CITY OF PORTLAND, MAINE

August 16, 2018

Project Name: **New 8-unit building: 7 residential units and 1 commercial unit condominium**
Project ID: Subdivision and Site Plan: # PLO00030-2018
Address: 28 Vannah Avenue, Portland CBL: 129 FO11 001
Applicant: Vannah White LLC (Thomas Greer)
Planner: Jean Fraser

PLANNING BOARD REPORT PORTLAND, MAINE

Drawing file: Drawings / C2.3 GRADING & UTILITIES PLAN.pdf

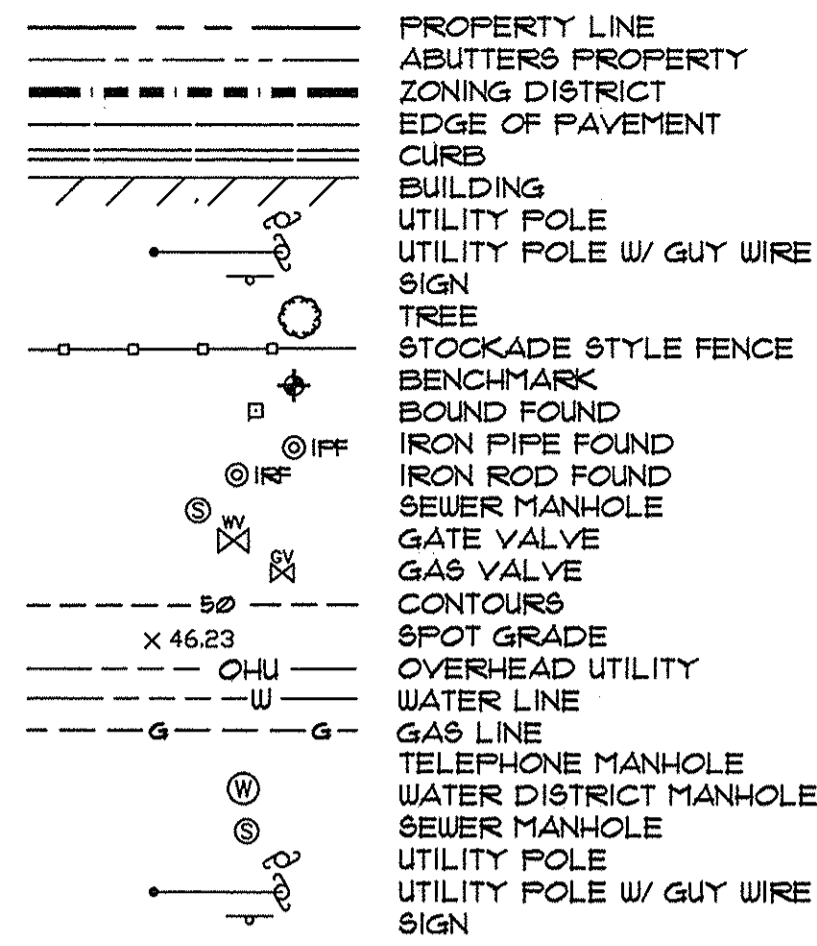
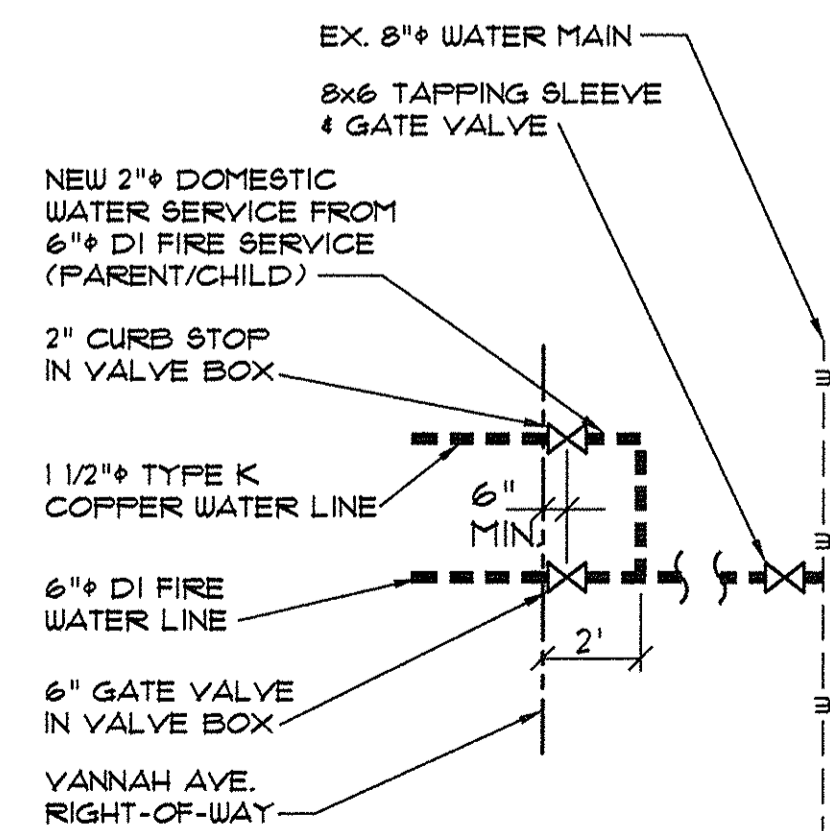
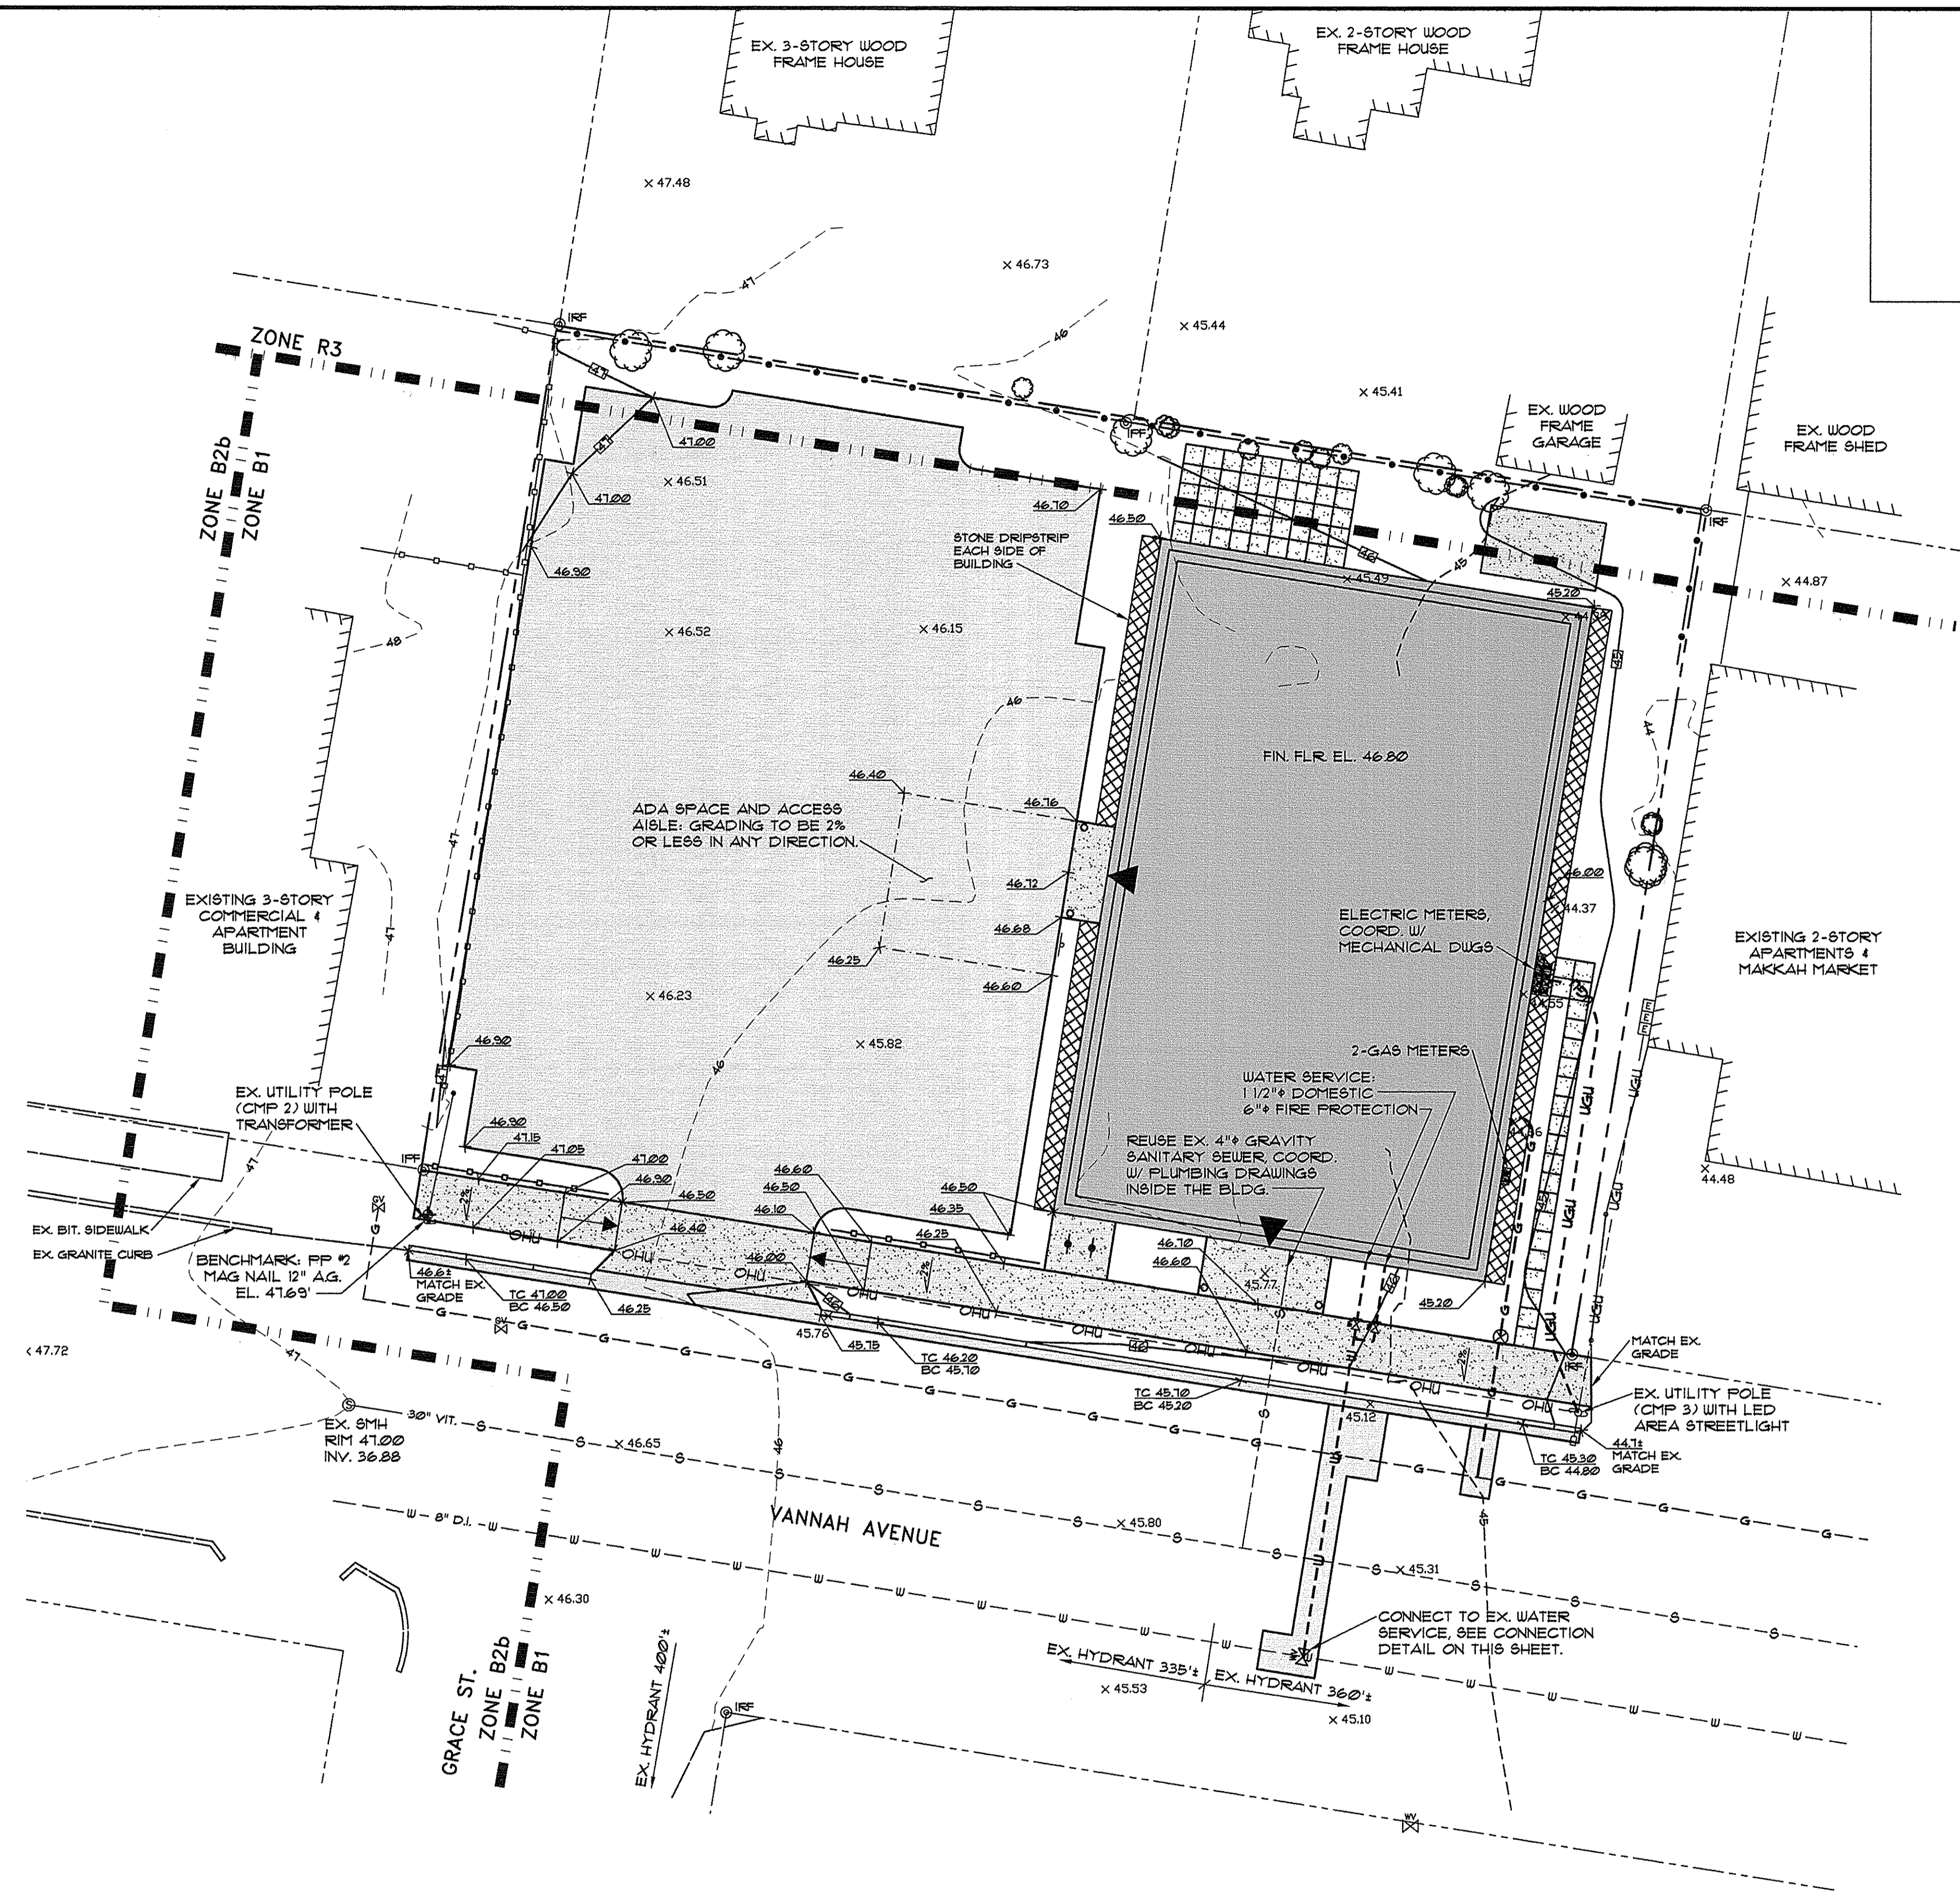
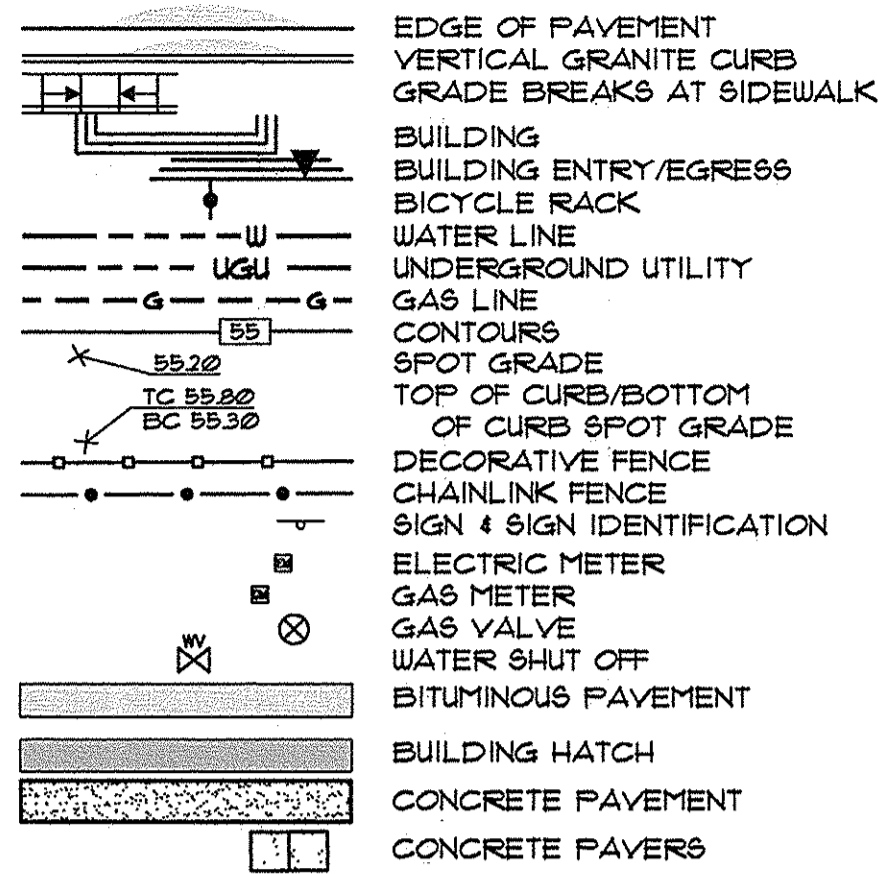
Other recommendations from the Board were to increase the buffer planting along the rear boundary to reduce the prominence of the fencing, and to clarify the drainage and grading, as the parking lot drainage appeared to be directed towards the building.

The proposal increases the impervious surface by 513 sq ft. The applicant revised the grading plan to address previous comments concerning the direction of stormwater flows. The Peer Engineering reviewer considers the proposals to be acceptable (Attachment 1), subject to a condition of approval requiring submission of the wastewater capacity letter.
